June 17, 2026

Department of Public Works – Stormwater Section
El Paso County**Re: Space Village Road Outdoor Storage; PPR233, CON2429, ESQ2430**

EAST POND SECTION F-F
NOT TO SCALE

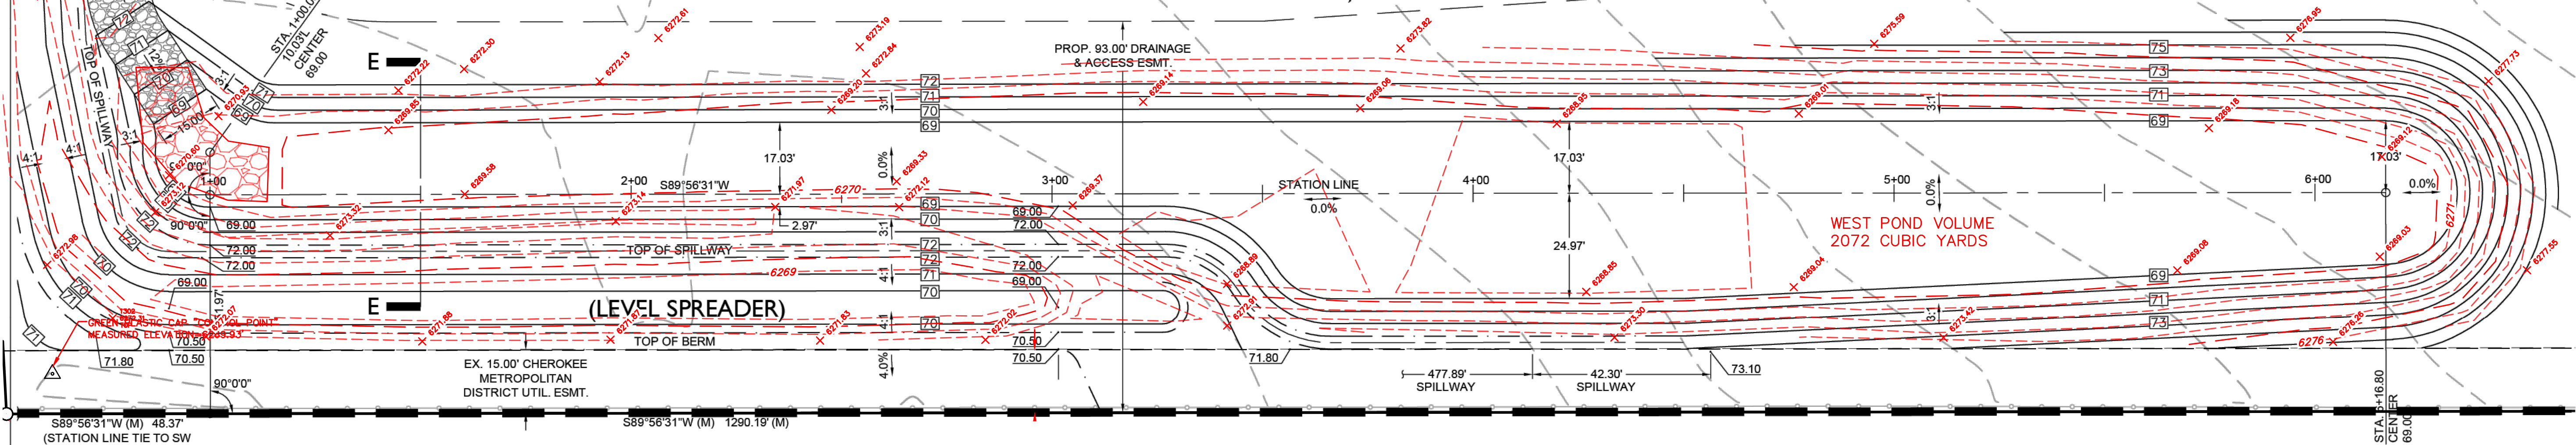
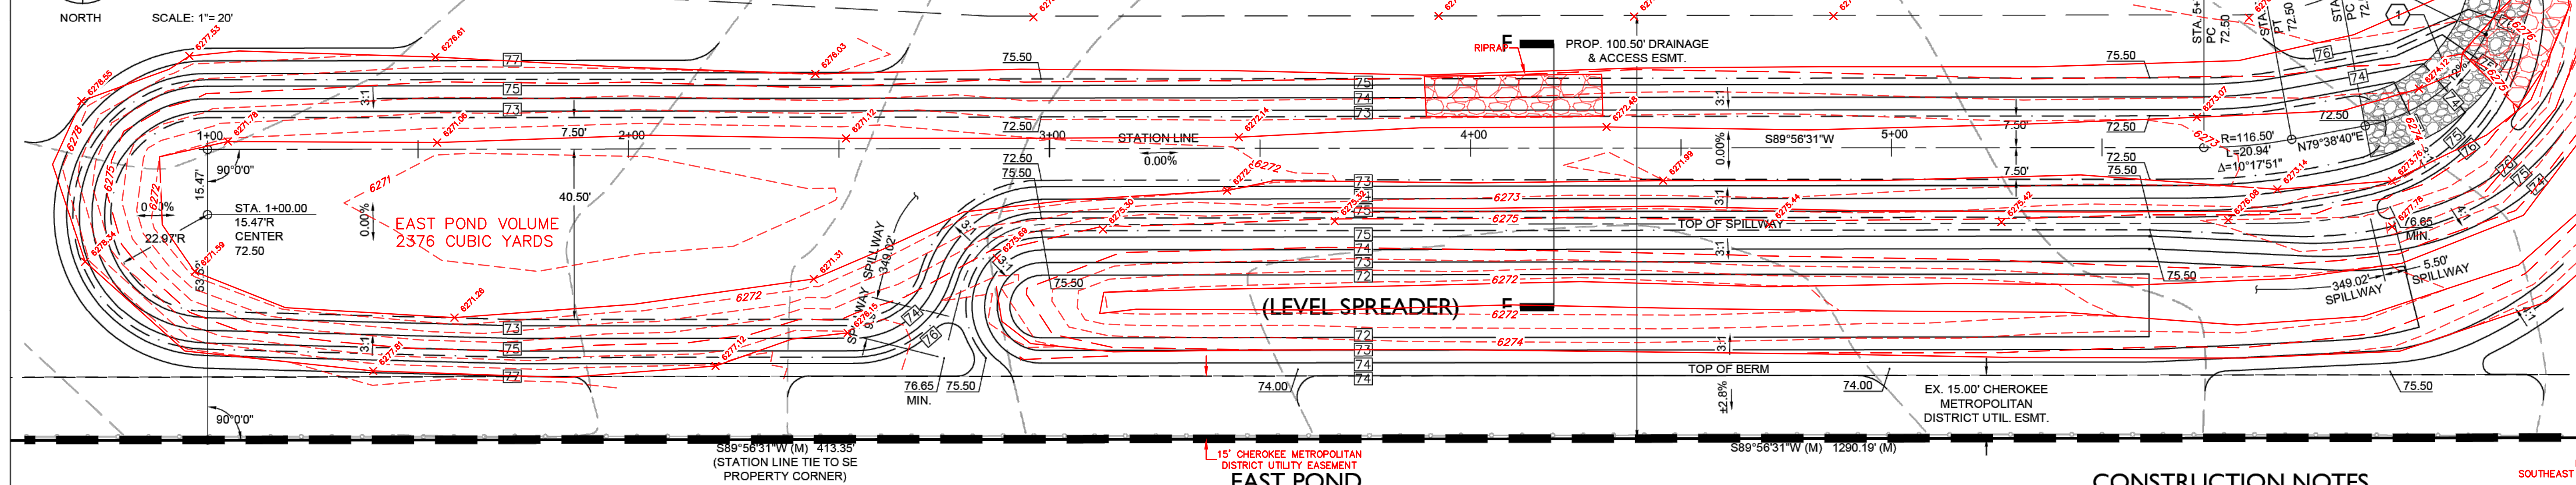
- Although most of the pond side slopes are shallower than 3:1, there are a few areas with the side slopes of each pond that exceed 3:1 (no steeper than 2:1).
- The East Pond will drain the WQCV in approximately 12.3 hours rather than the target of 12 hours.
- The West Pond volume is 2,072 CY, which is 87% of the design capacity.
- The West Pond has a freeboard of 0.53'.

A minimum of 1 ft of freeboard is required. Please make the necessary changes in the field and update the as-built drawings.

The area of the ponds are located is very sandy and unstable, and I anticipate that vegetating the embankments will be very difficult, even with 3:1 or shallower slopes. While the plans just call for seeding and mulching, soil amendments and erosion control blanket may be needed to establish vegetation.

I highly recommend that the embankment slopes are fixed in the field to be 3:1 or shallower.

This is acceptable but only if the calculations demonstrate that the pond is still capable of infiltrating the 100-year without activating the emergency spillway.
